WELWYN HATFIELD COUNCIL – DEVELOPMENT CONTROL
DELEGATED REPORT

APPLICATION No:	S6/2010/0342/FP
------------------------	------------------------

The existing annex would be demolished and a new structure would be built on a similar footprint. The proposal would measure approximately 7.2m in width by 10.4m in depth with a ridged roof to a maximum height of 6.2m.

Project: NORTHFIELD, WOODFIELD LANE, ESSFORD, HERTS AL9 6AU	
Drawing No: PROPOSED PILED C/P, NO BEAM LAYOUT	
Date: Mr and Mrs P MORGAN	
Drawn by: PSM	Checked by:
Approved by:	Date: OCT 2009
Drawing No: CR09-077-10/01	Rev:

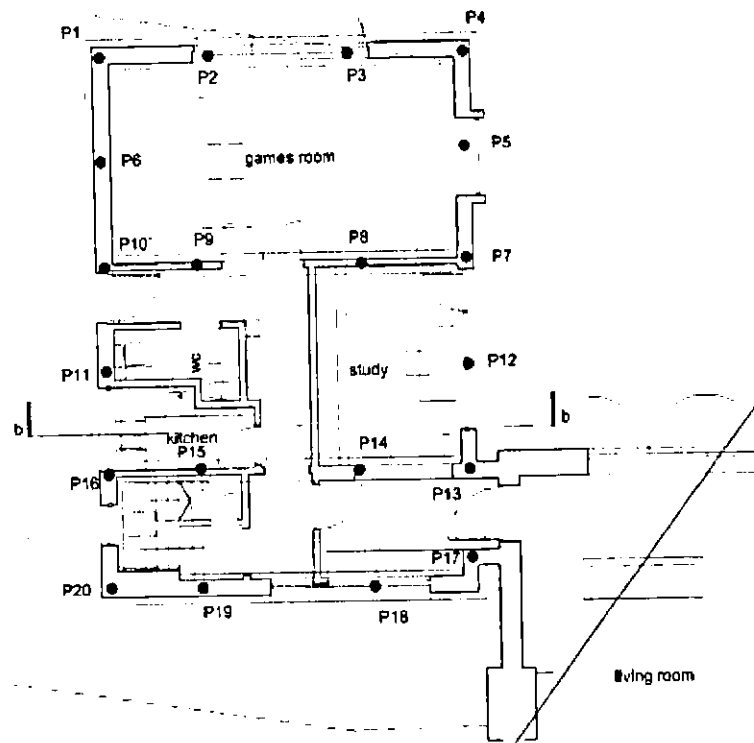
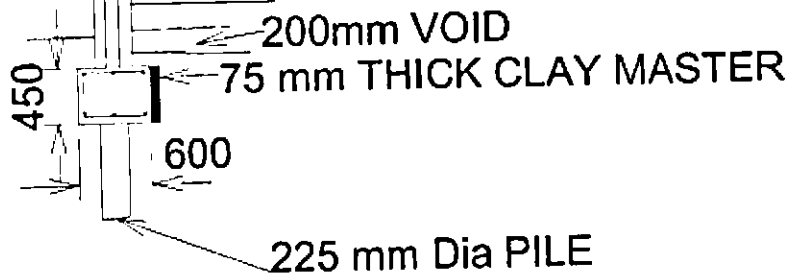
If the building is located as per drawing 0812/01 and the foundation is piled, as per the e-mail below, this would fulfil the current recommendations for building near trees.

1. C.2.1: Standard Time Limit
2. C.13.1: Development in accordance with approved plans/details 0812/01 REV.D & 0812/02 REV.D received and dated 03 March 2010.
3. C.5.2: Materials to Match
4. Foundations of the proposed development shall match the details submitted and assessed within the Arboricultural Impact and Method Statement by Henry Girling received and dated 03 March 2010.

NUMBER 0812 / 01

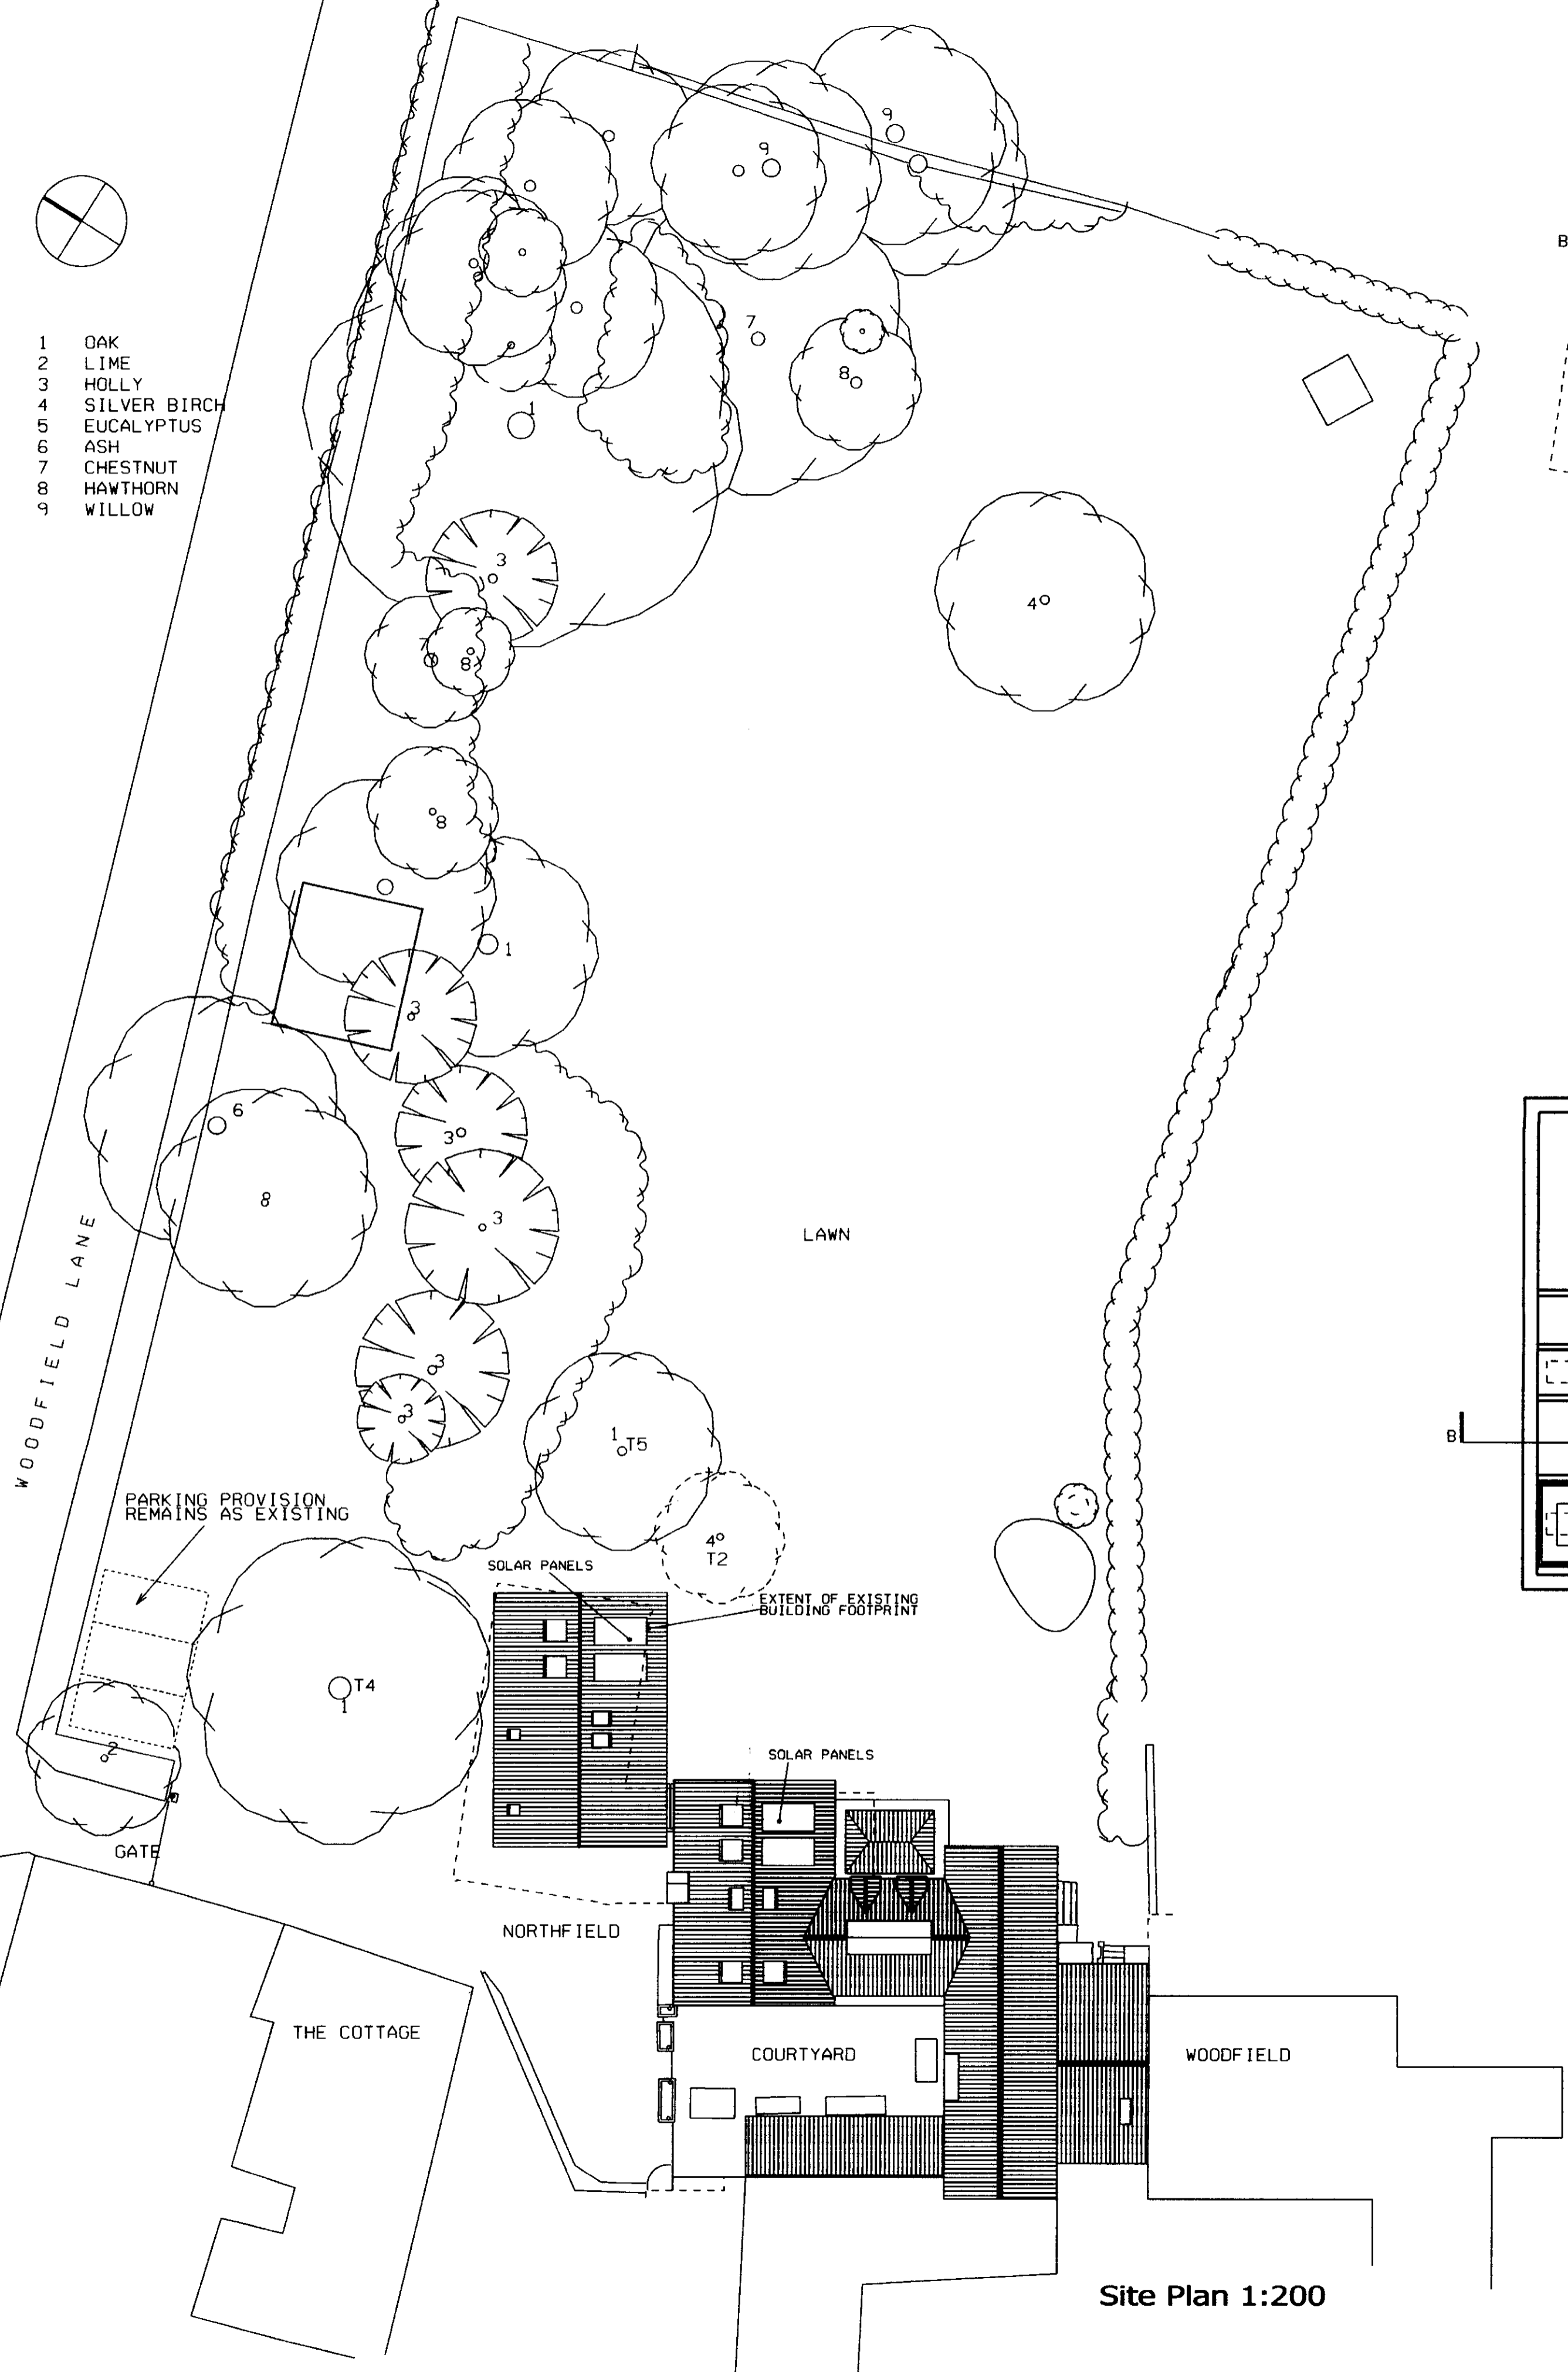
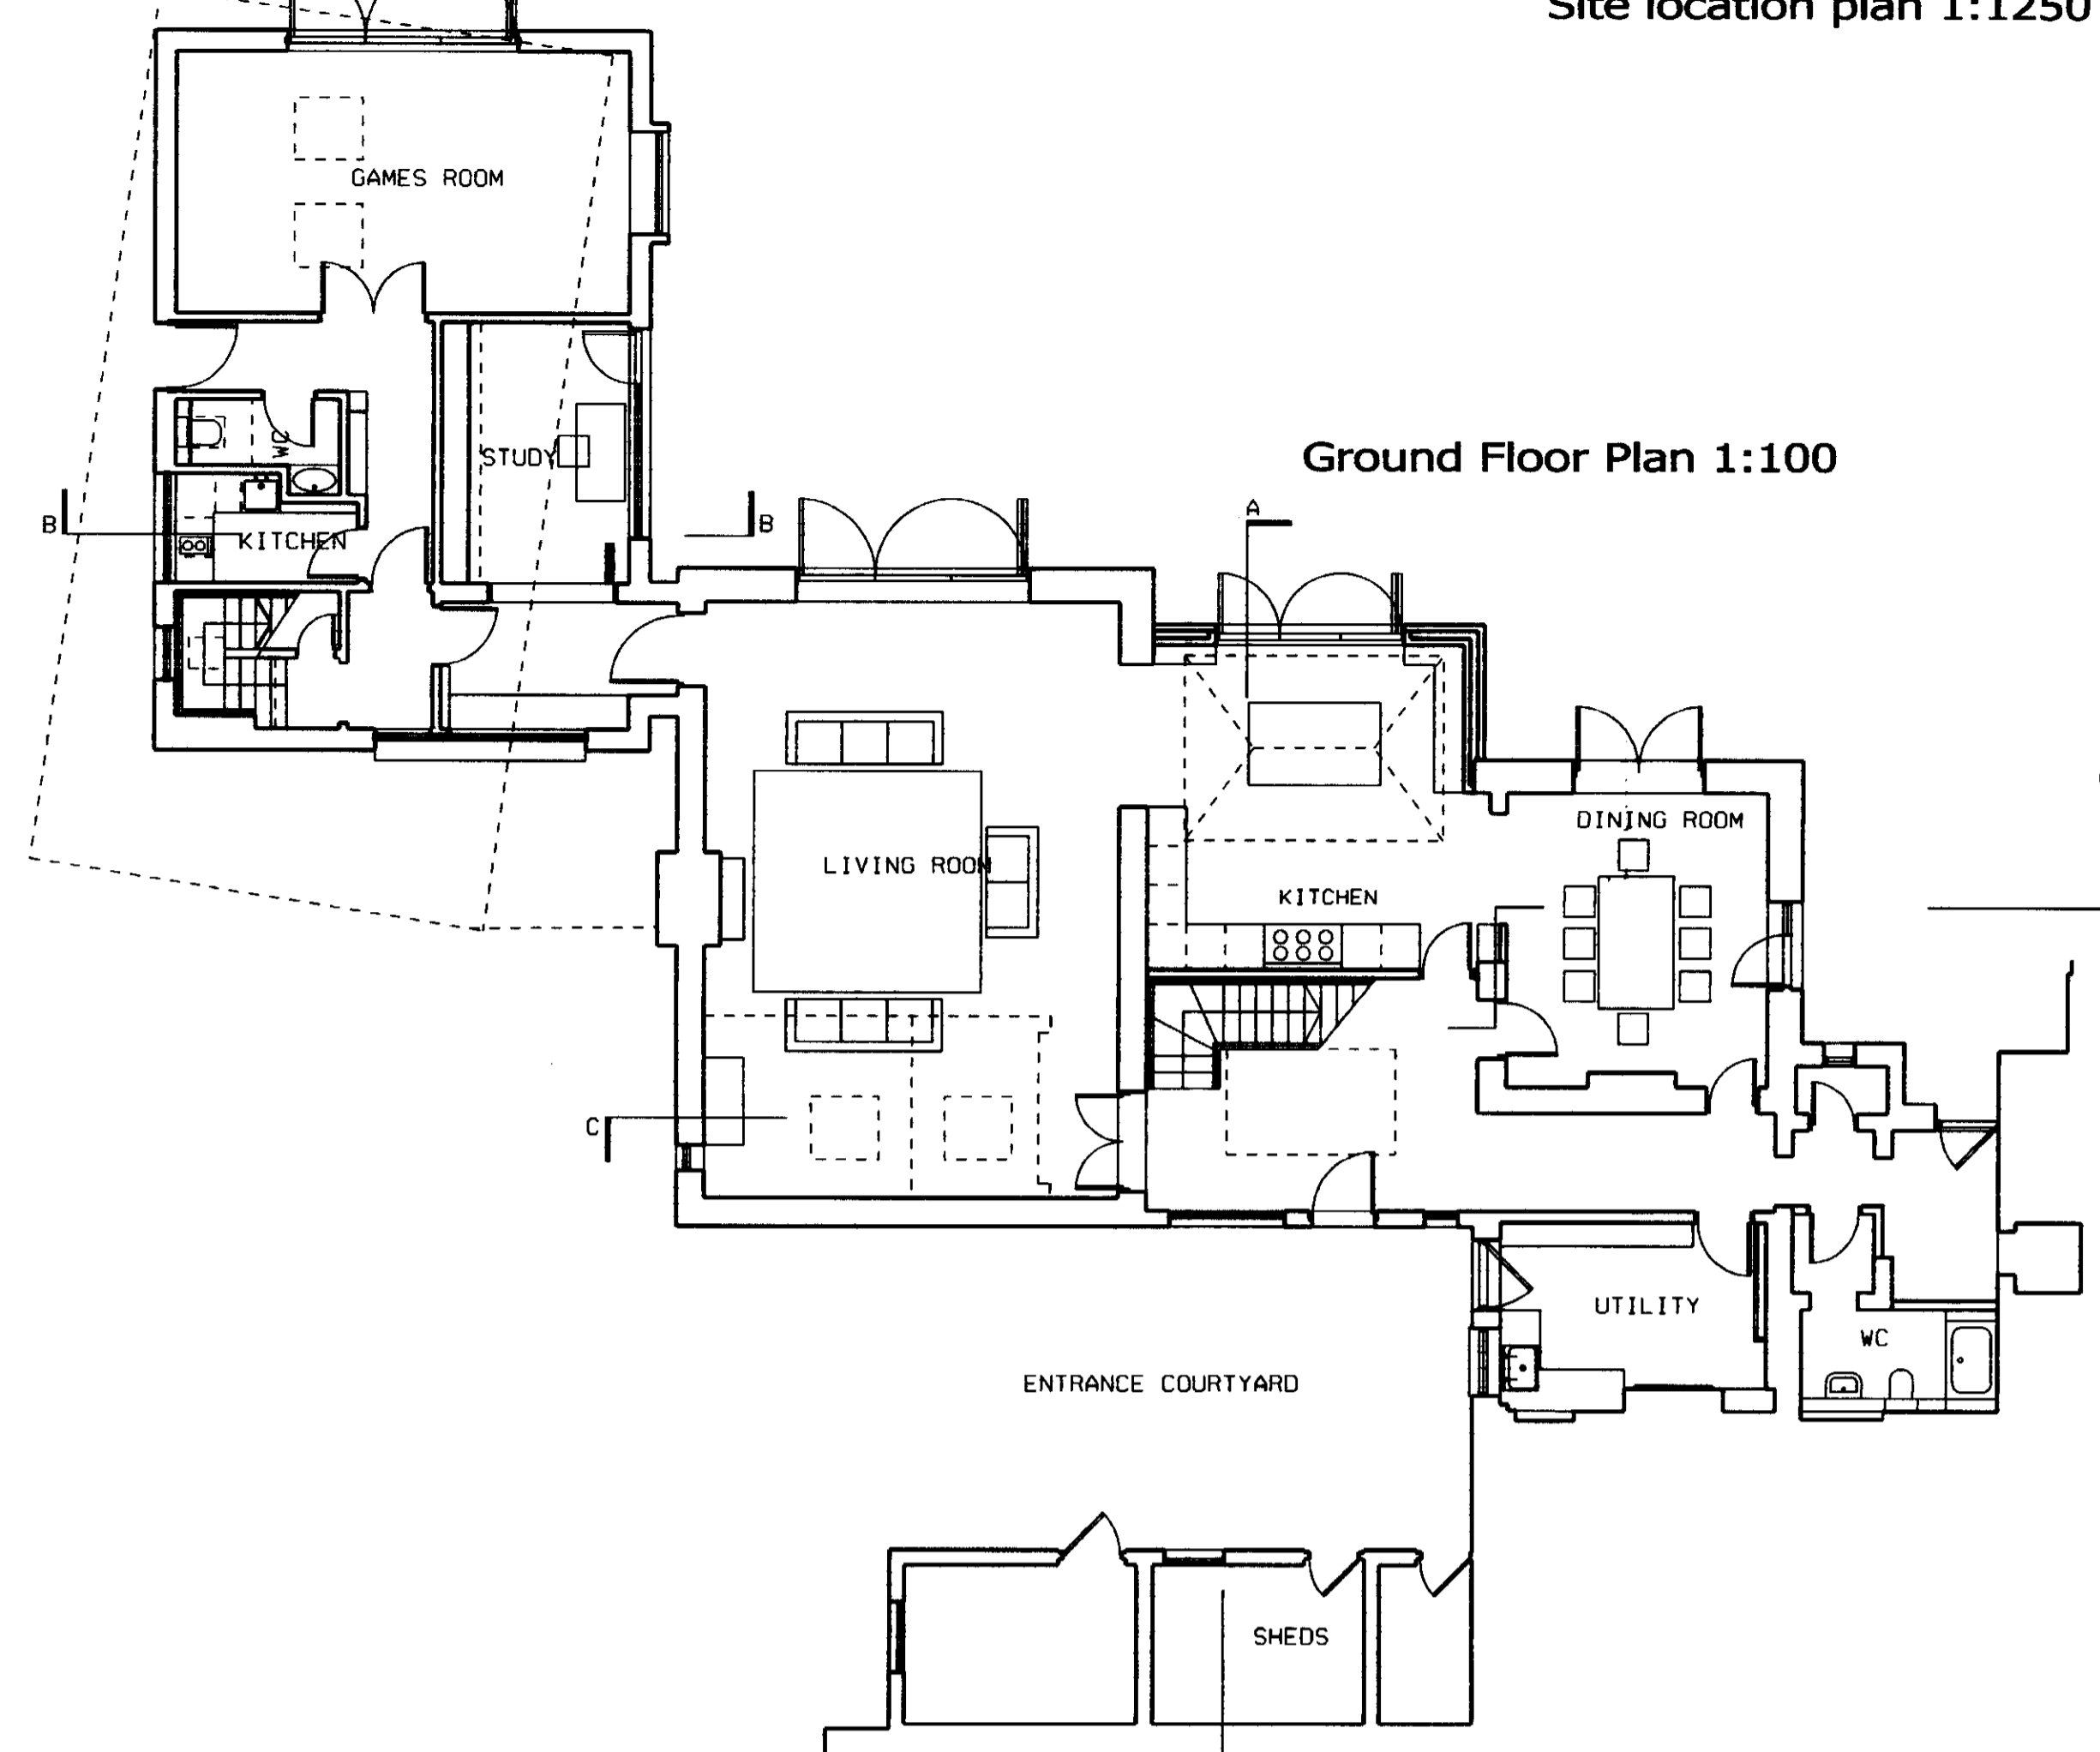
- any indication on where the replacement oak will go
- any indication as to where the protective fencing will go
- any indication as to what working zone will be required around the building and what method of protection the ground will have which is part of the Root Protection Area but exterior to the fenced off area

The proposed development would be mostly built on the footprint of the existing annex. However, the proposal would be partially built closer to a large mature oak tree. As the existing annex may have relatively modest foundations that the adjacent trees have grown to accommodate, the potential impact of new foundations has been investigated within the arboricultural implications assessment that has been submitted.
